**The Sandstone Precinct Stage 2 Modification 7 – Proposed Design Changes -  
Department of Education Building 35-39 Bridge Street, Sydney. (SSD 7484).**

Thank you for your request for the Heritage Council to provide advice in relation to this proposed modification for the Sandstone Precinct –the Department of Education Building (SHR No. 00744).

FOR APPROVAL
DRAWING TITLE
DEMOLITION PLANS
LANDS BUILDING - LOWER GROUND
EDUCATION BUILDING - BASEMENT LEVEL 01

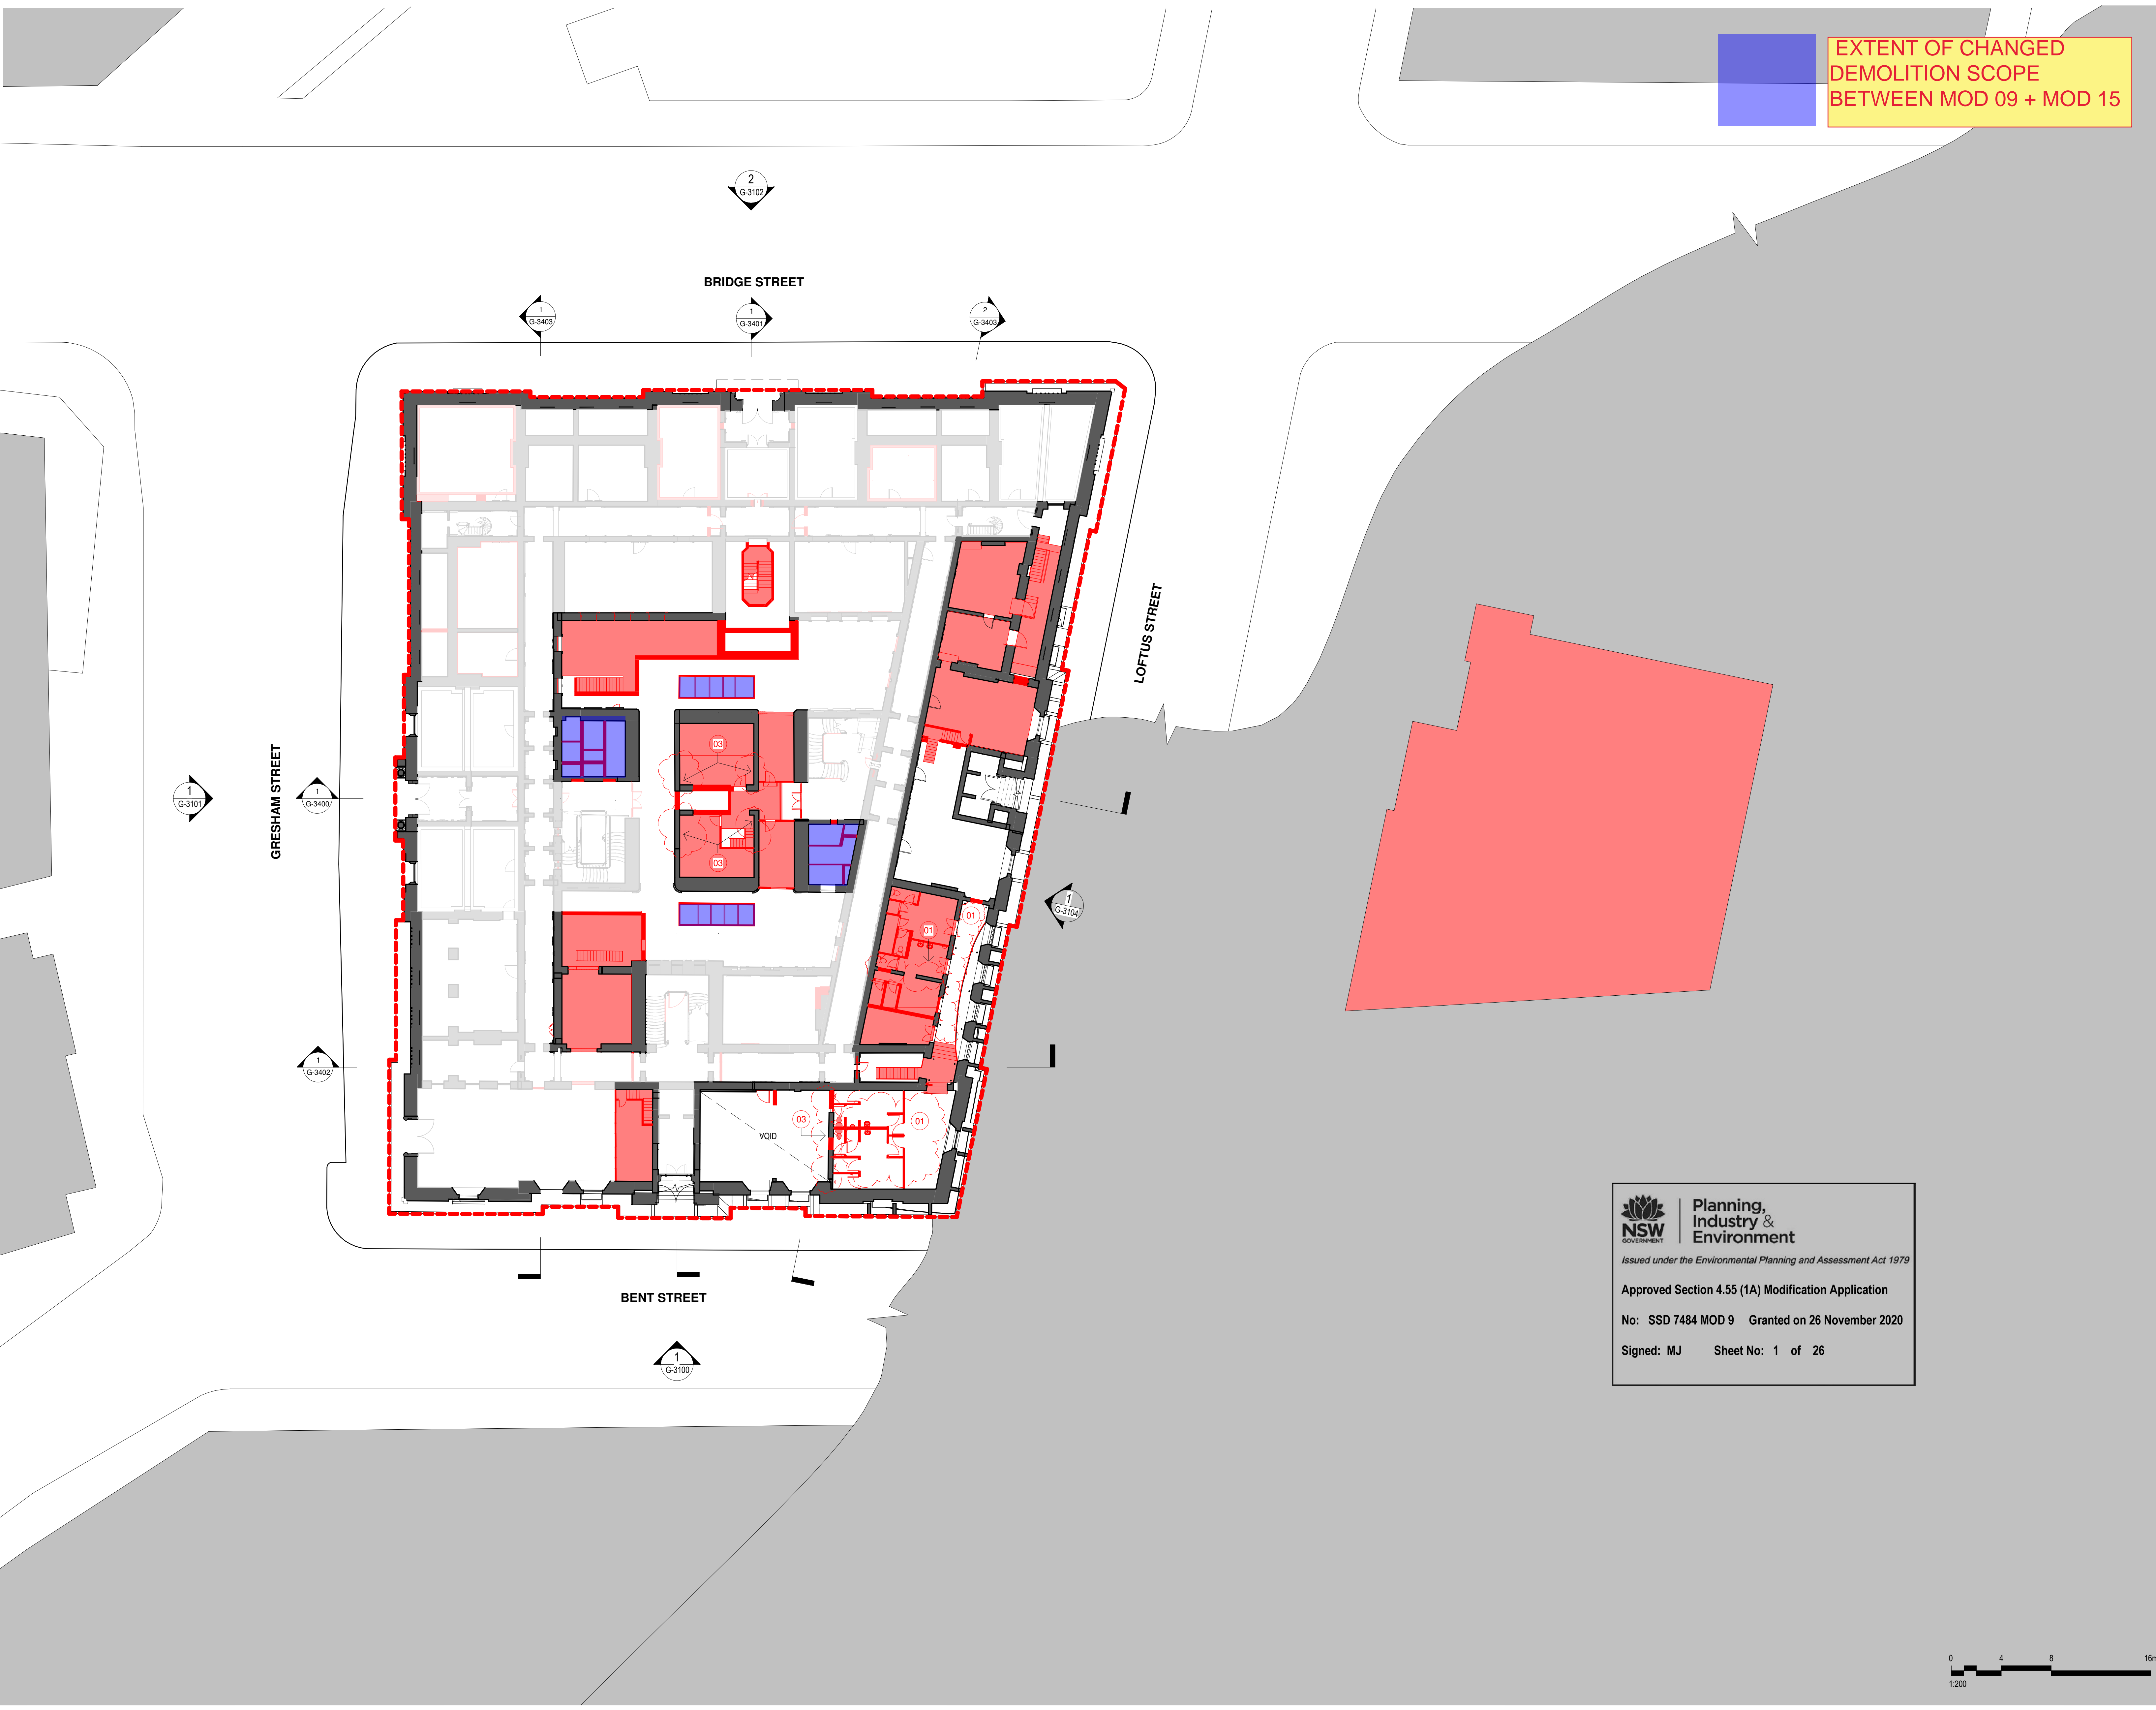
- The south west external tenancy has been replaced with a substation. Ausgrid require the development's substation to be located within the Education Building.
- The external tenancy has been relocated to the north east corner.
- The north west corner of the building will now accommodate guest rooms.
- Changes to the Loftus Street laneway to accommodate DDA access

It is noted that some Exceptionally Significant fabric will be adversely impacted to accommodate the substation as required by Ausgrid, despite an options analysis and Dispensation options being discussed with Ausgrid. The current proposal has been chosen as the option with the least heritage impact. To mitigate this impact, and to meet the requirements of *CMP* Policies for Elements of Exceptional Significance (6.9.3 and 6.10.4), HNSW makes the following recommendations:

- the required modifications to the sandstone façade fabric and selection of new materials and colours to accommodate the substation must be appropriately detailed and implemented in consultation with and to the satisfaction of Urbis, the project Heritage Consultant and
- any original sandstone fabric and steel window grilles required to be removed to provide access to the substation shall be salvaged and retained on site for future use.
